Outer Dowsing Offshore Wind

The Applicant's Comments on Deadline 1 Submissions

Deadline 2

Document Reference: 19.4

Figure 7.3

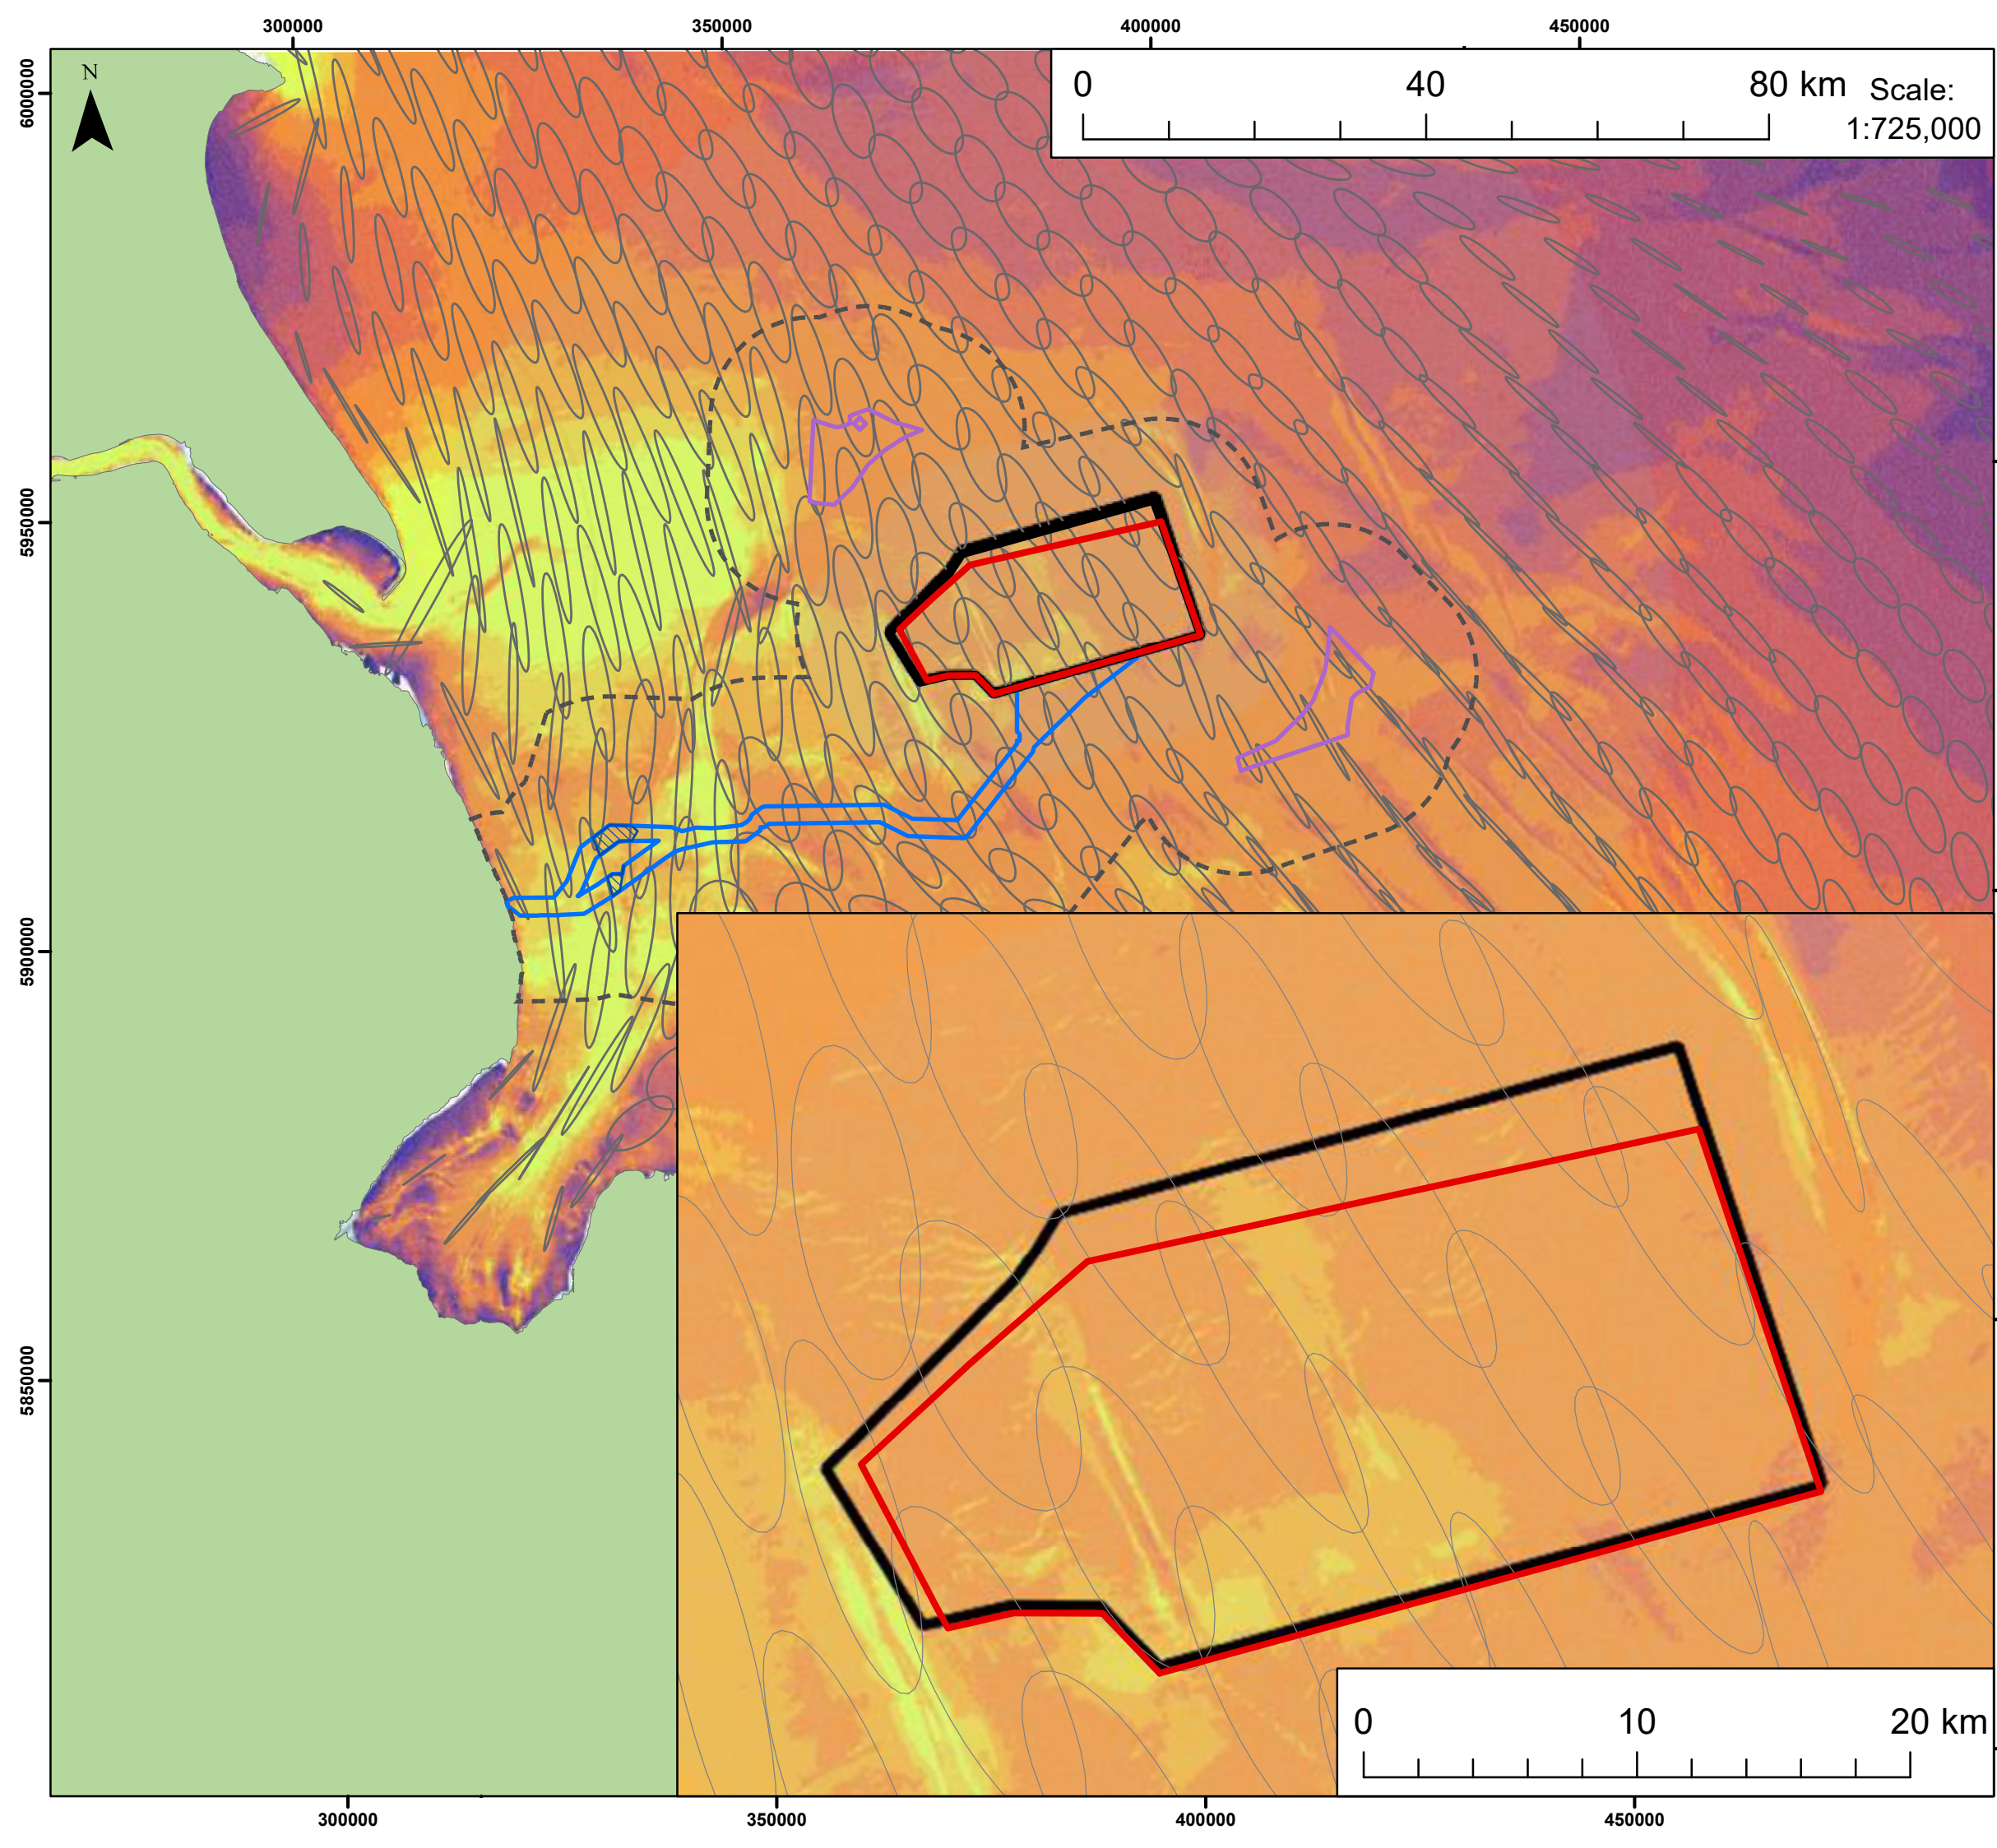
<p>Section 4. Disturbance Contours – Harbour Seal</p>	<p>It is unclear if the disturbance contours for harbour seal in Figure 11.4 [APP-099] of Chapter 11 [APP-066] overlap with The WNNC SAC. Natural England requests to see a figure containing the noise contours as presented in Figure 11.4 of Chapter 11 with the border of The WNNC SAC to understand the extent of the overlap. Furthermore, the barrier impacts from the piling at the Offshore Reactive Compensation Platform (ORCP) was not evident until the</p>	<p>n/a</p>	<p>The Applicant has identified that that both Figure 11.4 (APP-099) and Figure 11.5 (APP-099) of Chapter 11 (APP-066) contained the incorrect dose response curve for seals. The figures incorrectly showed the monopile 5dB SEL_{ss} disturbance contours from 120-180 dB, which is the harbour porpoise dose response curve (Graham et al., 2017), whereas the correct dose response curve for seals is 145-</p>

ID	Natural England Comment	Natural England's Advice to Resolve Issue	Applicant Response
	<p>noise contour figures were published in the Environmental Statement. This new evidence is potentially concerning considering the harbour seal decline.</p>		<p>180 dB as referenced in Whyte et al., (2020). The Applicant will submit revised versions of Figure 11.4 and 11.5 with the monopile 5dB SEL_{ss} disturbance contours from 145-180 dB at Deadline 3. The Applicant can confirm that the correct dose-response curve (Whyte et al., 2020) has been applied in the assessment of impacts to harbour seals and grey seals in section 11.7 of Chapter 11 (APP-066) and the error is only relating to the figures.</p> <p>The Applicant will add the WNNC SAC to the revised versions of Figure 11.4 at Deadline 3. However, the Applicant can confirm that noise contours from the array, artificial nesting structure and ORCP do not overlap with the WNNC SAC. The introduction of the ORBA would not change these conclusions as the worst case scenario piling location in the SW remains the same.</p> <p>The Applicant also considers that barrier effects have been included within the assessment of disturbance from piling (both Wind Turbine Generators (WTG and ORCP) in the assessment of Impact 5 of Section 11.6 of Chapter 11: Marine Mammals (APP-066) which demonstrates that intermittent piling will not cause barrier effects. Natural England previously agreed barrier effects for operational phase could be scoped out at the EIA Scoping stage. Barrier effects are considered within the Cumulative Effects Assessment of disturbance from piling (both WTG and ORCP) in section 11.7 of Chapter 11 (APP-066). Even using a highly precautionary 26km Effective Deterrence Range, the significance of the impact was assessed as minor (not significant) and did not result in an effect on the population trajectory over time.</p>
